From: Carolyn Pannell [REDACTED]
Sent: 08 November 2014 13:53
To: Anita Gardner
[REDACTED]

Subject: RE: EP/149/14/PL RESPONSE TO EAST PRESTON AND KINGSTON PRESERVATION SOCIETY'S OBJECTION LETTER

Proposed Street Elevation

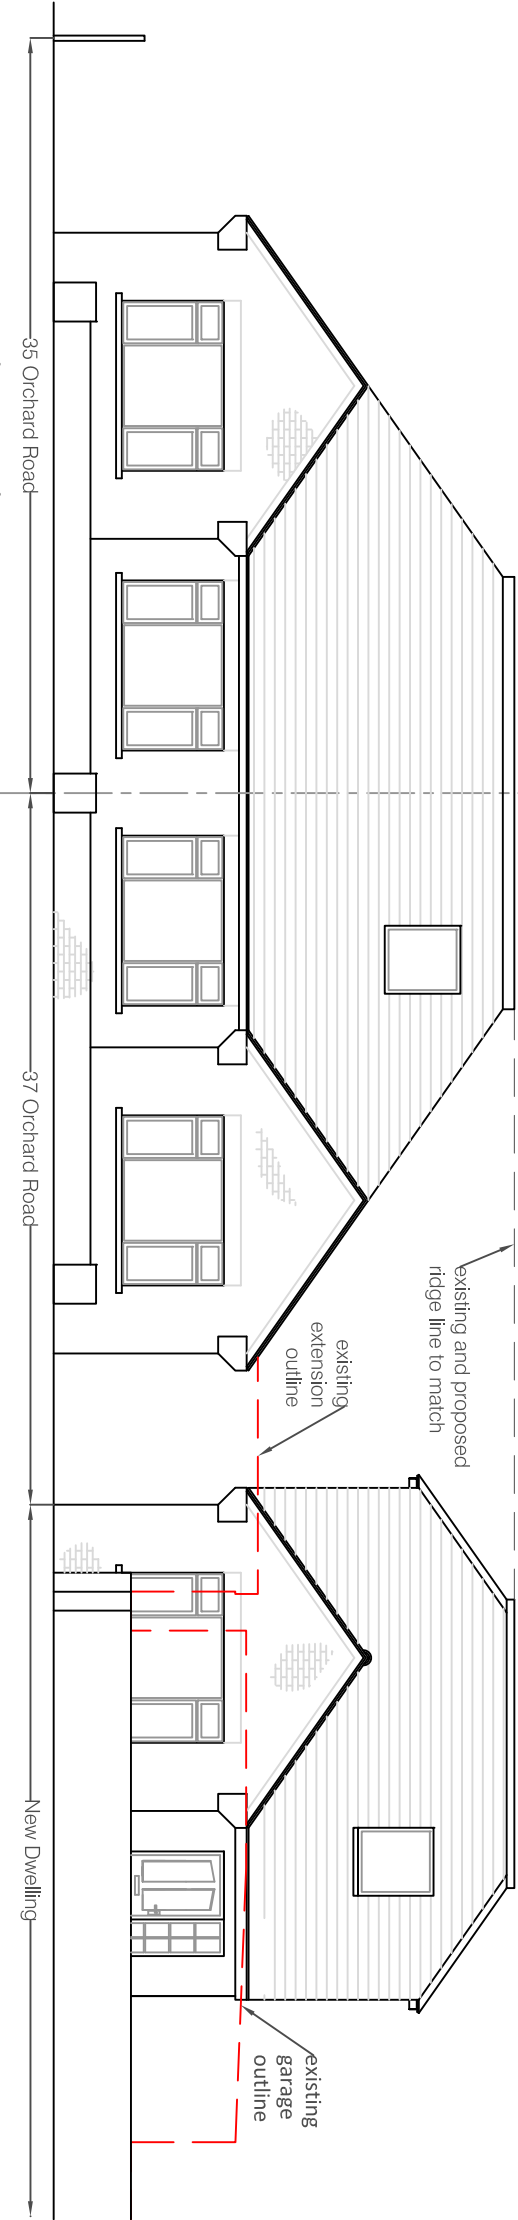
The new design has addressed ALL previous issues raised by the Inspectorate, neighbours and Arun Council. It now mimics the dwelling of no. 37 and it's surrounding neighbours. Is smaller in both design and roof area. Has given more available space between it and number 37. So, cannot be deemed as cramped **VIEW PLAN ELEVATIONS**, yet Mr David Sawers has submitted under reference OWPC4217 once again.

"The site on the proposed dwelling is too narrow to accommodate a three bedroom house of an acceptable appearance"!

The Letter then states:- **"The proposed building is therefore poorly proportioned, being too narrow in relation to its height and quite different to the proportions of its neighbour to the west."** "It also presents a facade that is dominated by the front slop roof". Its design contrary to.....

- (a) It's **not higher** as Mr Sawyer's previously also tried to state. It is the **SAME height as no. 37** Refer to plans CLEARLY showing this?! So the property to the West **REMAINS UNAFFECTED**.

- (b) It has the **same low front gable appearance** and the entrance has been placed on the front instead of the side. For the East Preston VDS states "**New Builds should be Compatible with,, but NOT necessarily the SAME, as the existing buildings in the ROAD**".

- (e) The new design plans **CLEARLY SHOWS** it neighbours no. 37 and no, 35 which **BOTH HAVE** a facade that is a front slope appearance roof with **LOW FRONT GABLES**. The new Design is the **SAME** as these and other dwellings in Orchard Road?! So this comment **CANNOT** be deemed once again, as a **VALID** point, it is **erroneous**.

- (e) Scale. **The overall height will match the height of No.37**
- (f) Scale. The **footprint** of the proposed house is **80.2m sq** and the proposed plot measures **310m sq**.

Rear Elevation (south)

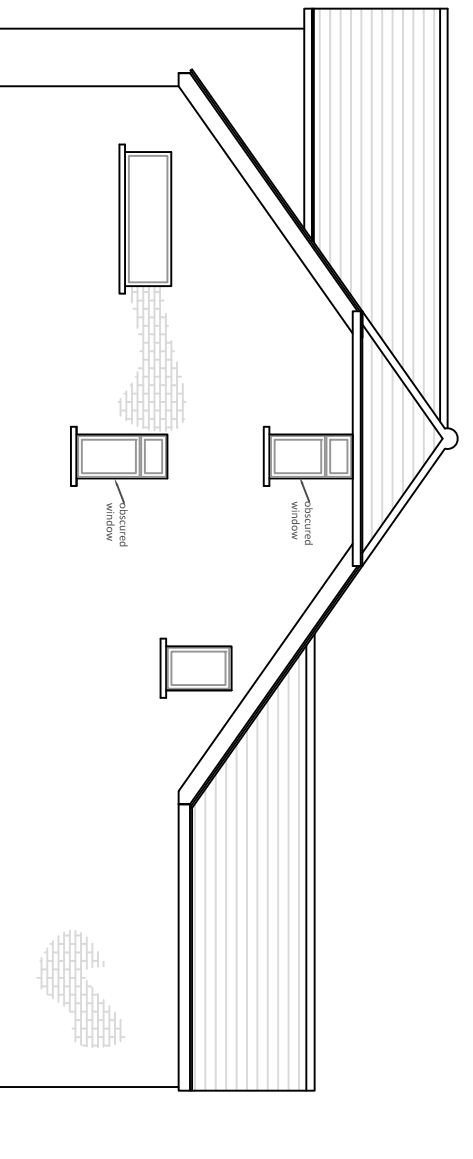
Mr Sawers then states: "**The windows of the two bedrooms upstairs would overlook the rear of the properties in Windlesham gardens.. reducing the privacy these now enjoy**"

- (b) There is **ONLY ONE** window on the plans facing **SOUTH towards Windlesham Gardens, NOT TWO**. An erroneous comment and not valid once again.
- (c) The plans clearly show that the distance from the new dwelling to the closest point of the boundary **MEETS BUILDING REGULATIONS**.

- (d) A dwelling in Windlesham Gardens has the **SAME** dormer similar appearance overlooking dwellings in Orchard Road. Picture will be provided.
- (e) To **COMPLY** to Building regulations has meant that a **FIRE ESCAPE** to the upper bedrooms **MUST BE** provided. Hence the upper bedroom window, which has been kept as small as possible.

- (f) **FURTHER** privacy of Windlesham Gardens will **NOT BE** affected from that, that we can already see from the upper bedroom windows of no. 37. So is an **INVALID COMMENT**.
